Your Ref: OWPC17791
Our Ref: BE/17/18/PL 02-10-2017
Please ask for:
Mr S Davis

Proposed 2 bed bungalow
37 Norbren Avenue Bersted

Thank you for your internet representation made on 4th April 2018 which has been recorded as '**an objection**' with the comments as follows:

Farhad Aarabi	
PROJECT	Proposed Bungalow 37 Norbren Avenue, Bognor Regis
TITLE	Proposed Elevations
CLIENT	Mr & Mrs Clarke
SCALE	1: 100
DRAWING NO.	906-02
DATE	16/09/2017
rev.

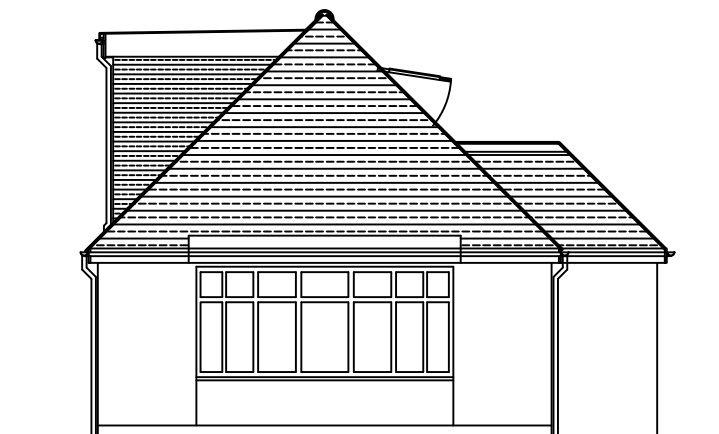
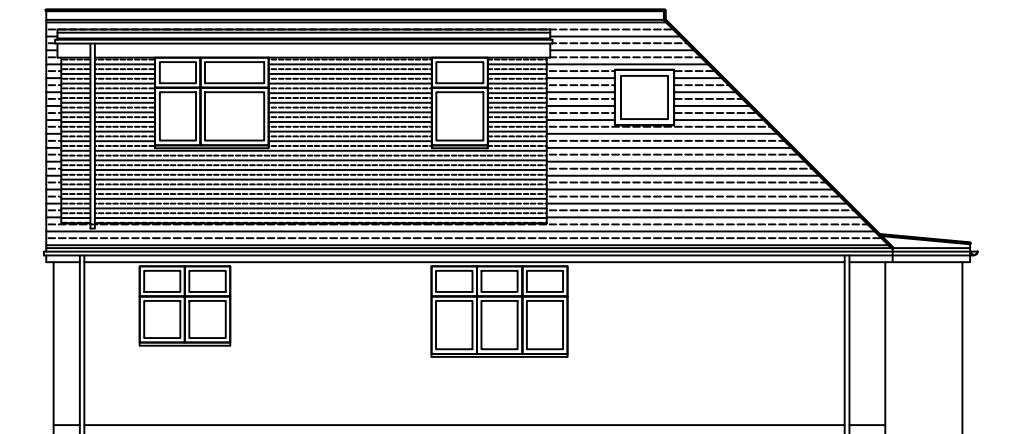
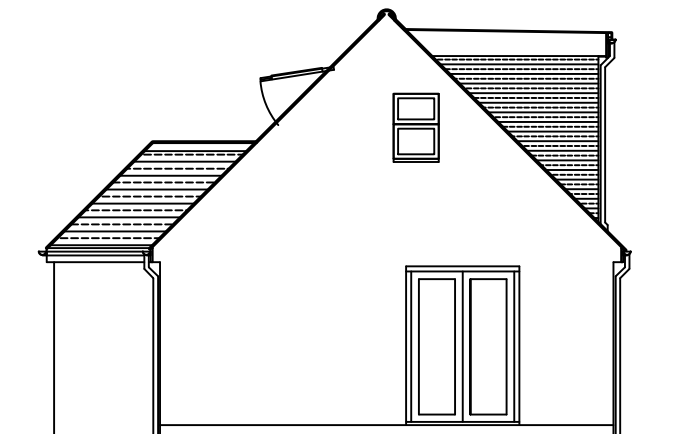
The proposed chalet bungalow would be totally out of character with the rest of the estate. It would be an eyesore for the area. Parking would also be a problem with so many cars parked on that corner
